**Fort Halstead - Hybrid Planning Application 19/05000/HYB**

I am writing to register my objection to the planning application above.

**FORT HALSTEAD, KENT
 PROPOSED HIGHWAY LAYOUT
 STAR HILL ROAD JUNCTION**

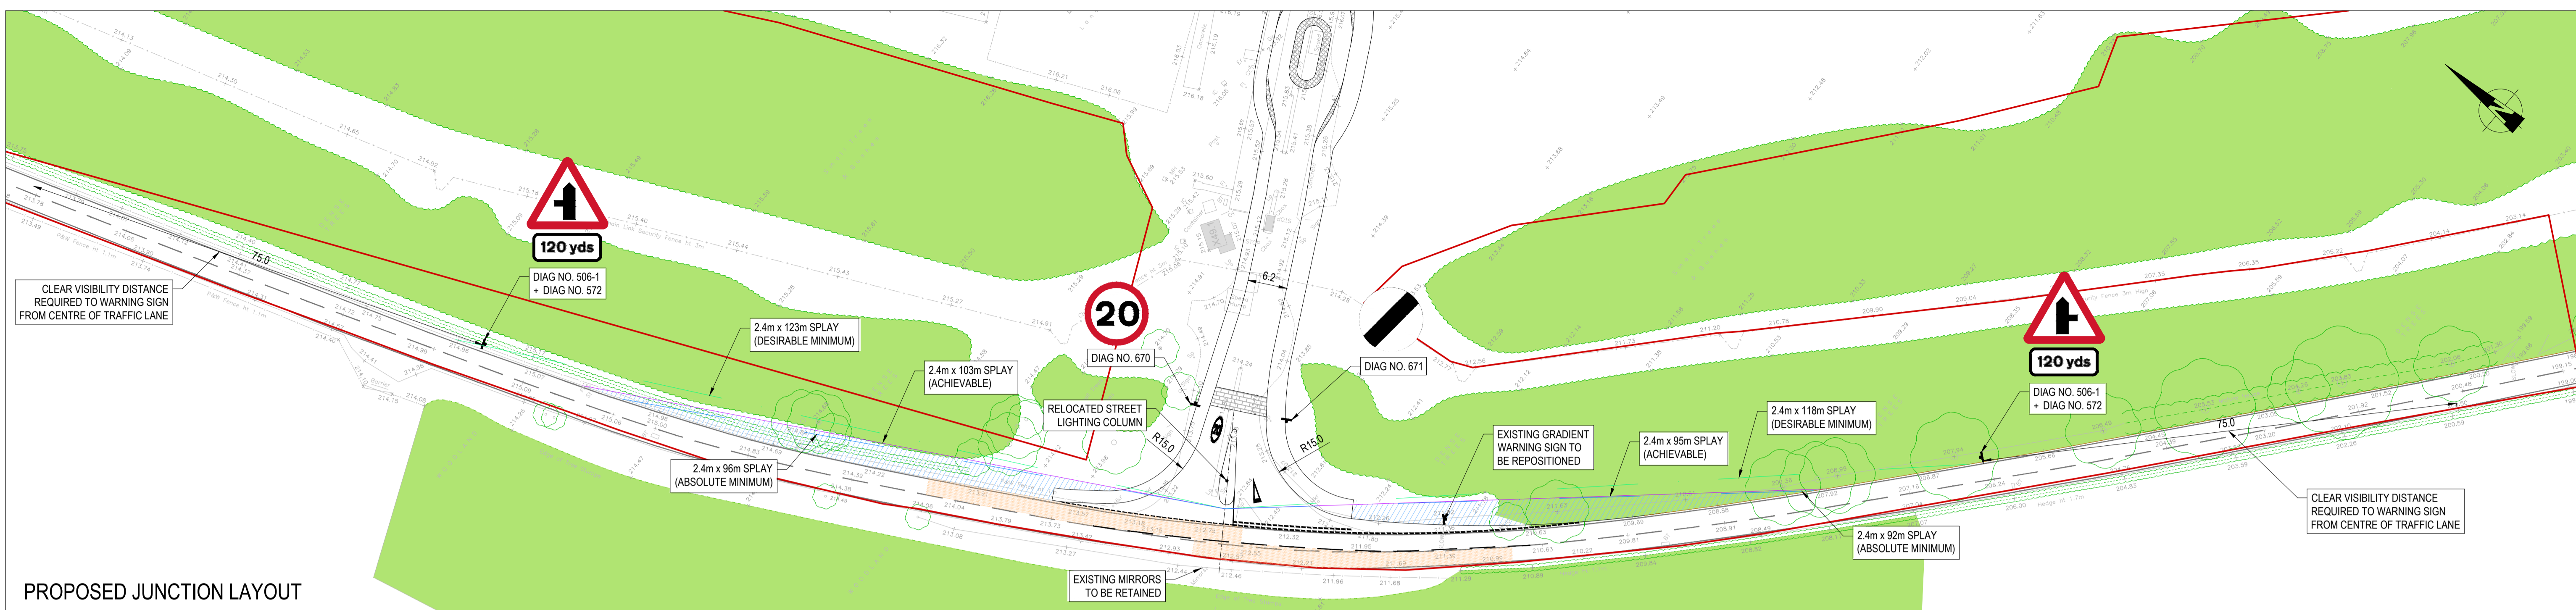
The Technical Note, dated 26th November 2014, in the Transport Assessment, Appendix O describes Star Hill Road as "...a narrow road, unlit rural lane with a width of approximately 5.0 metres and has a steep gradient of up to 10%...". The Star Hill access is located on a bend just below the brow of the hill and presents a significant challenge, because of the poor visibility, when leaving the Fort Halstead site in either direction (as shown in Appendix O, Photo 3). Whilst I note that the 2015 junction improvement drawing has been included with the hybrid planning application, it is disappointing that a scheme that just exceeds the minimum requirement has been reused.

**FORT HALSTEAD, KENT
 STAR HILL ROAD JUNCTION
 VEHICLE SWEEP PATH ANALYSIS**

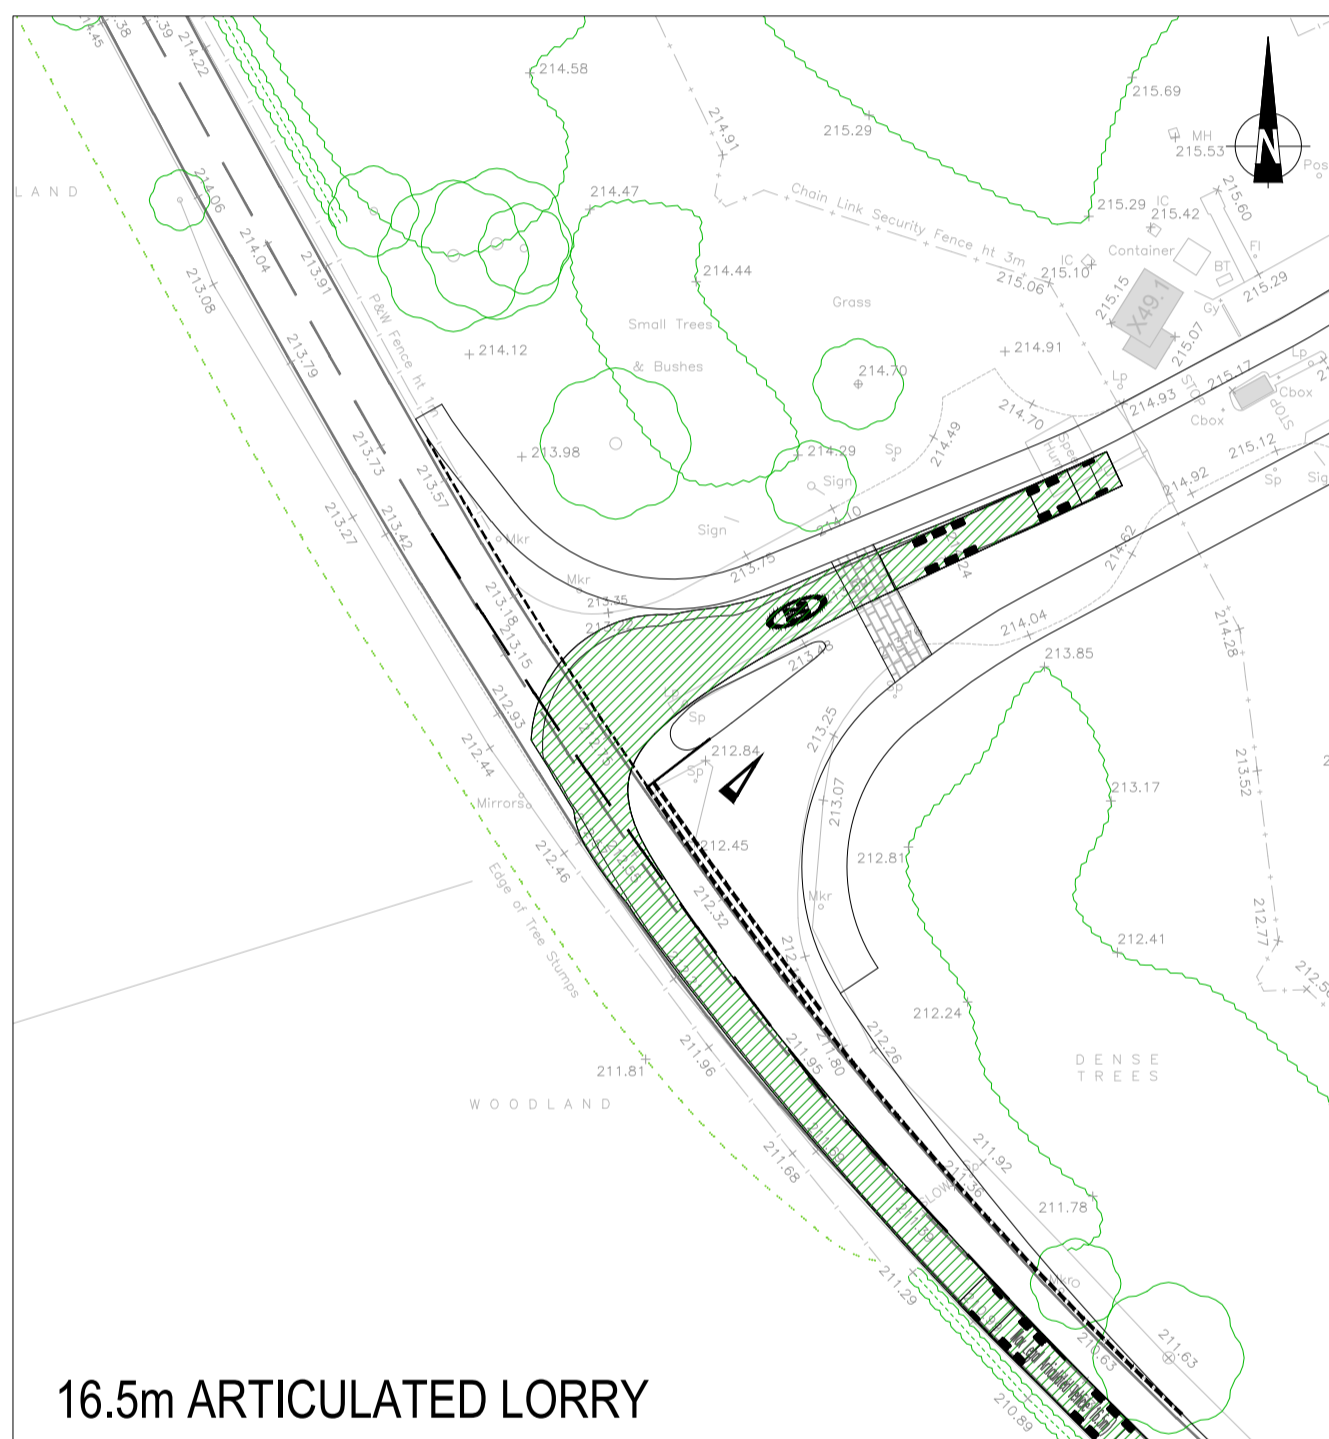
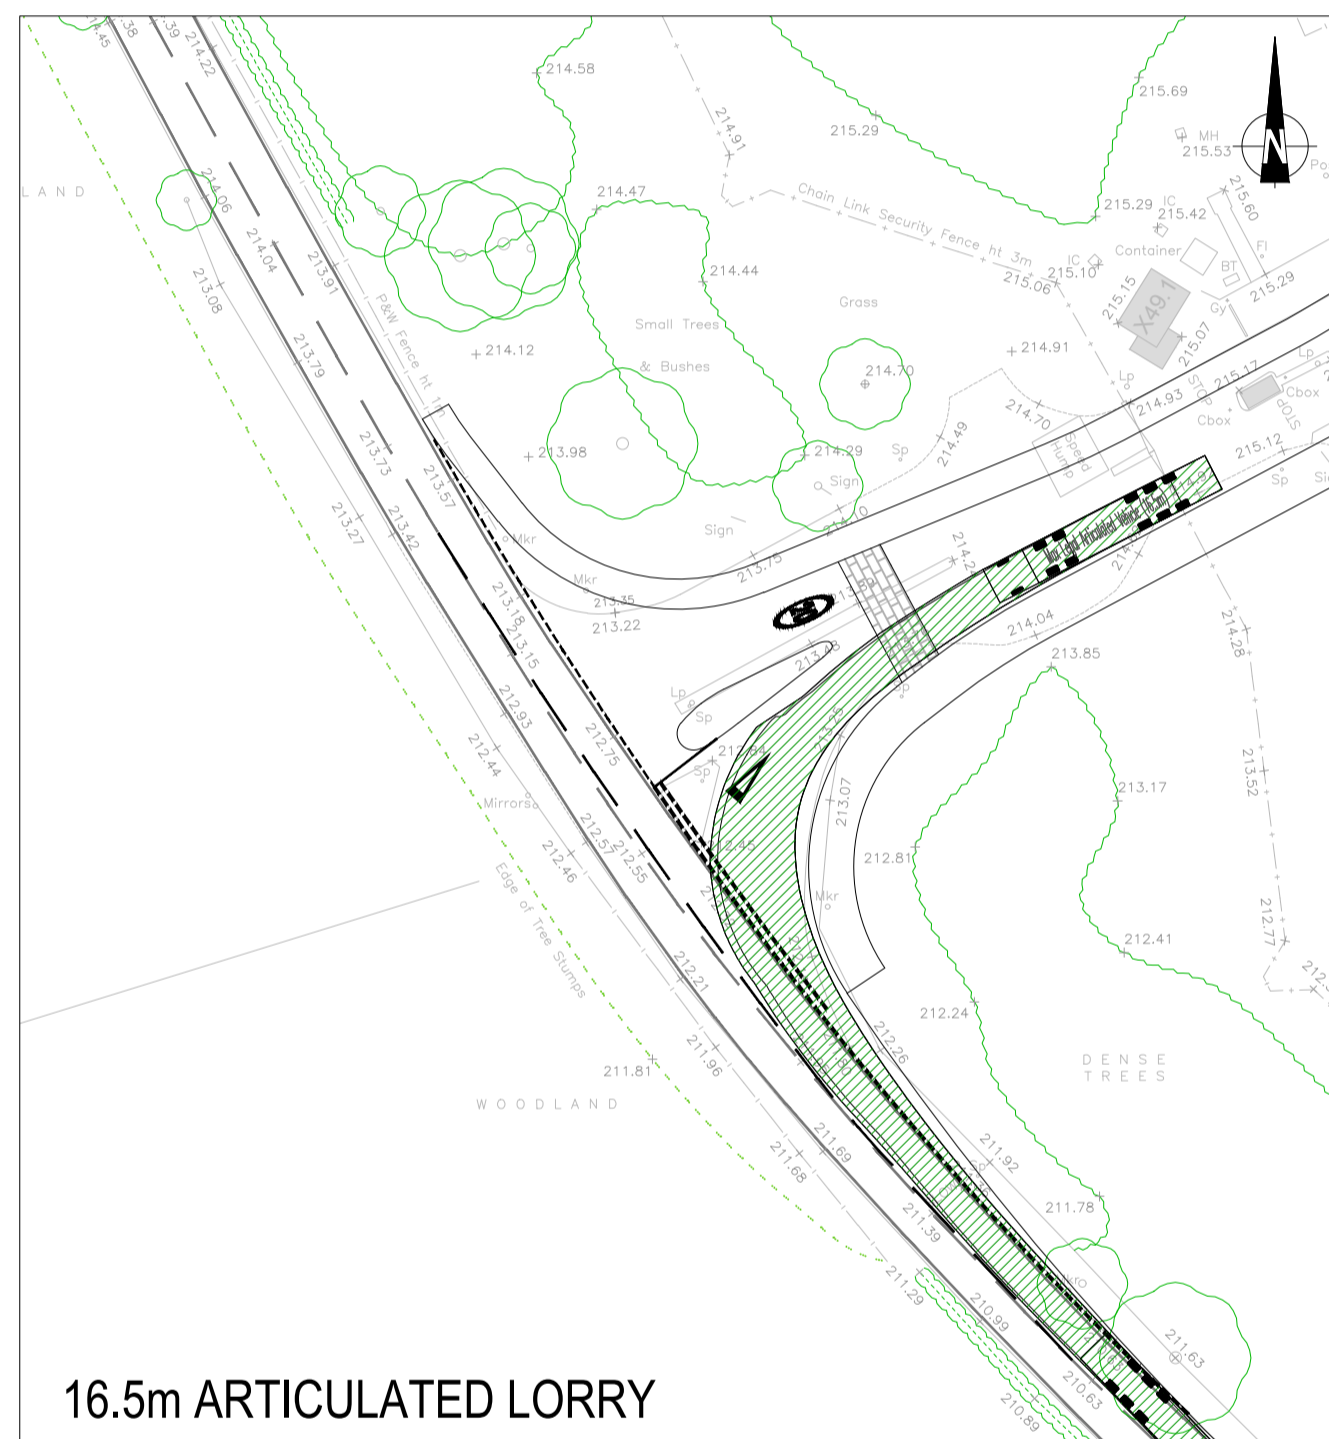
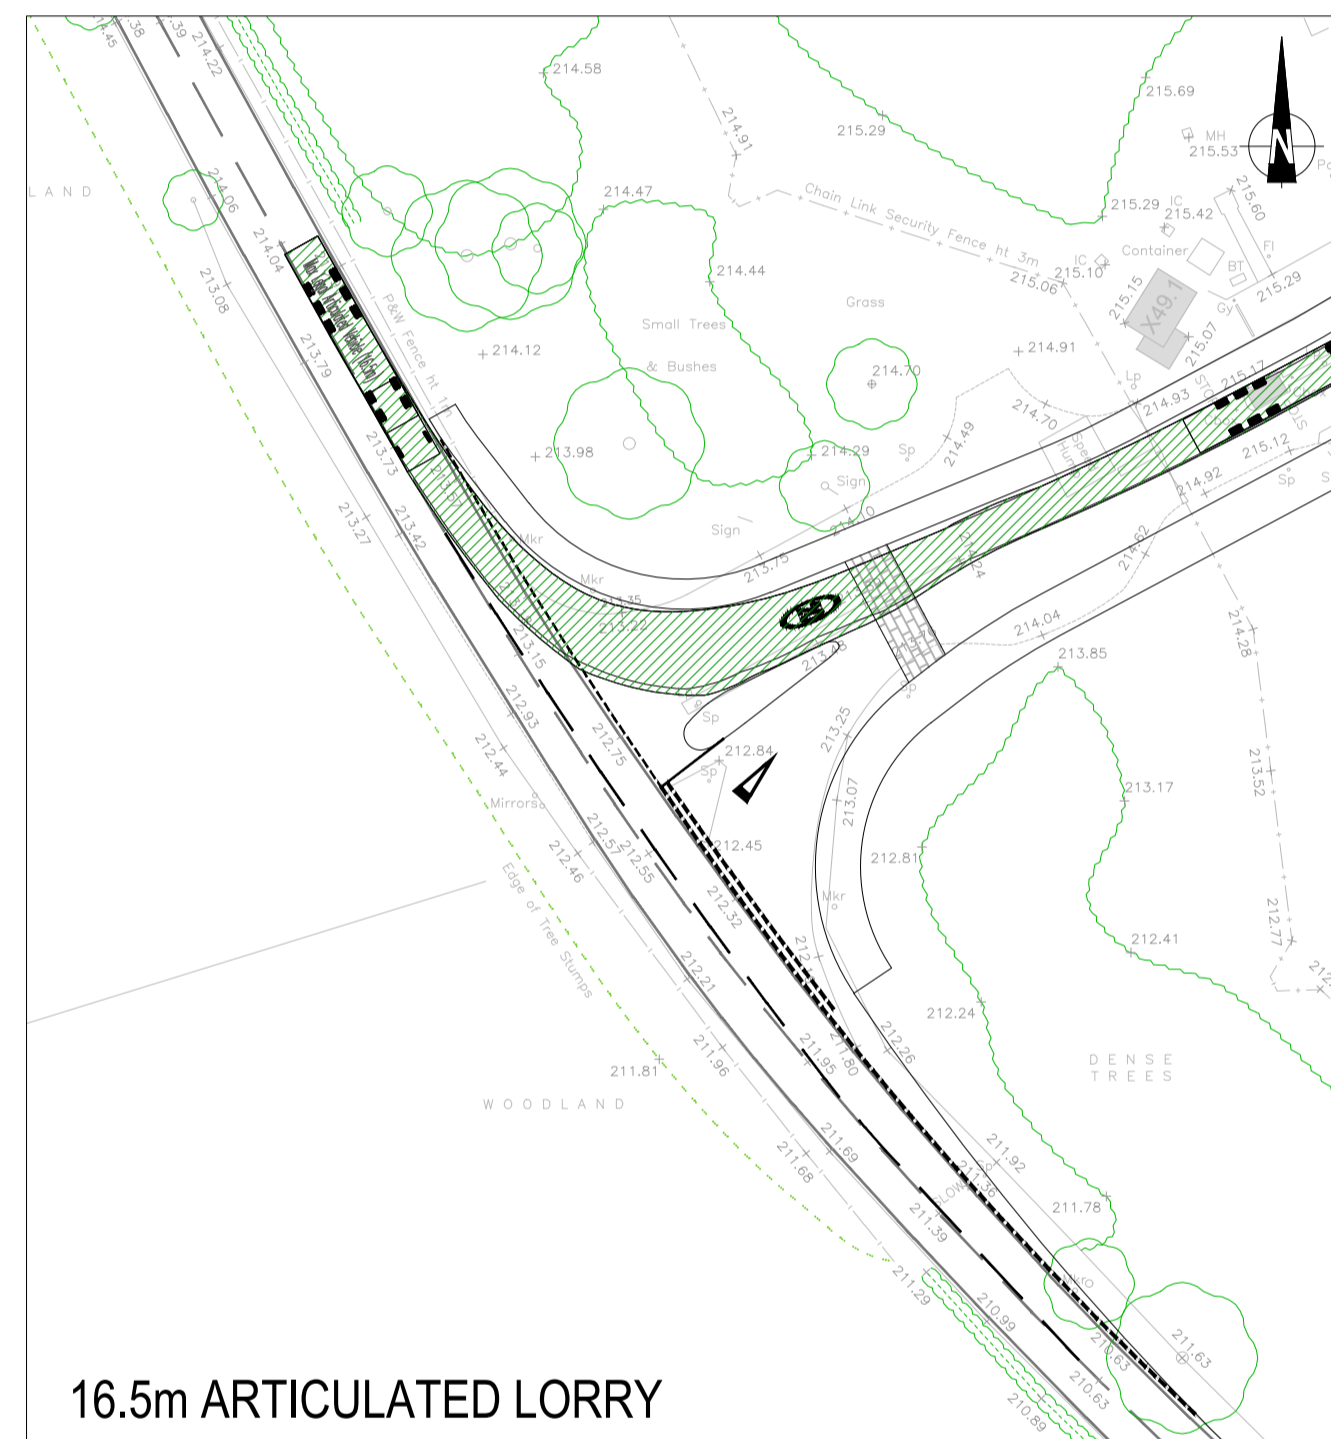
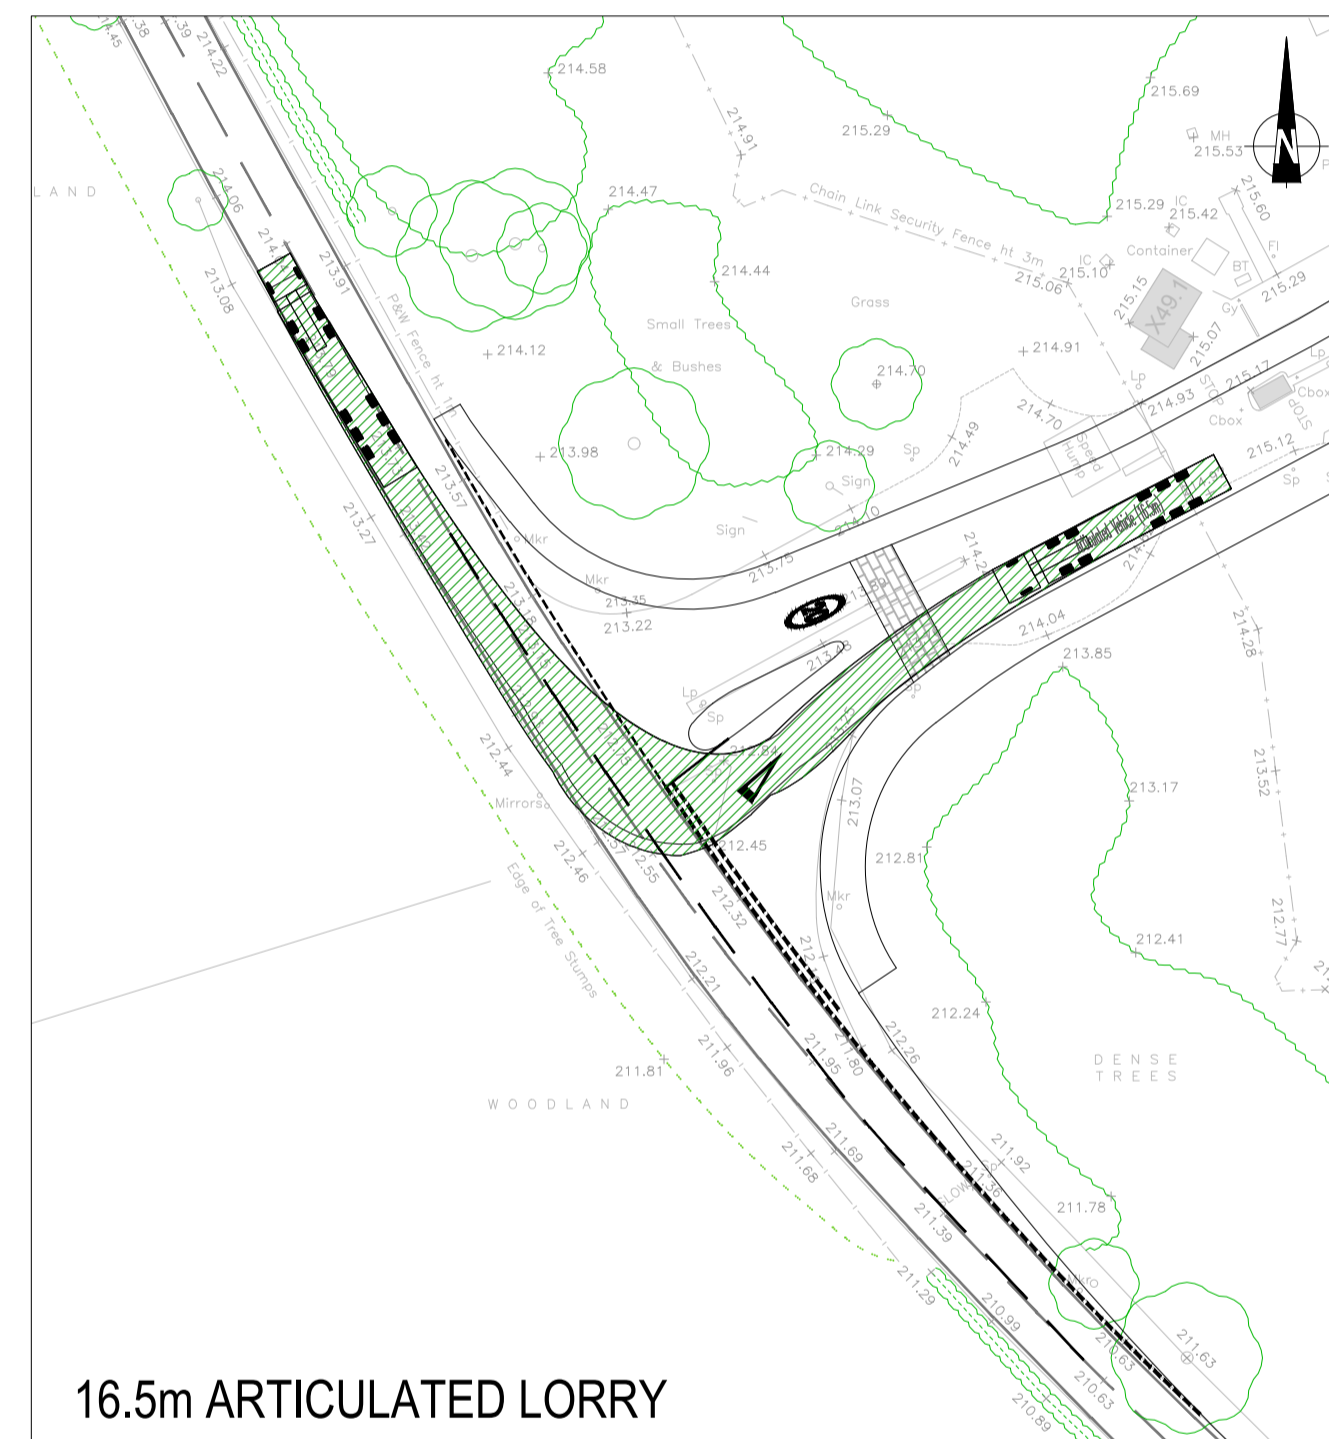
In addition, "Tapers on the junction corner radii to help large vehicles to turn without overrunning the centreline of the major carriageway" are being proposed on the Star Hill access and Transport Assessment, Appendix H includes swept path analysis for 16.5m articulated vehicles. It seems wholly inappropriate that 16.5m articulated vehicles should be encouraged to use Star Hill Road.
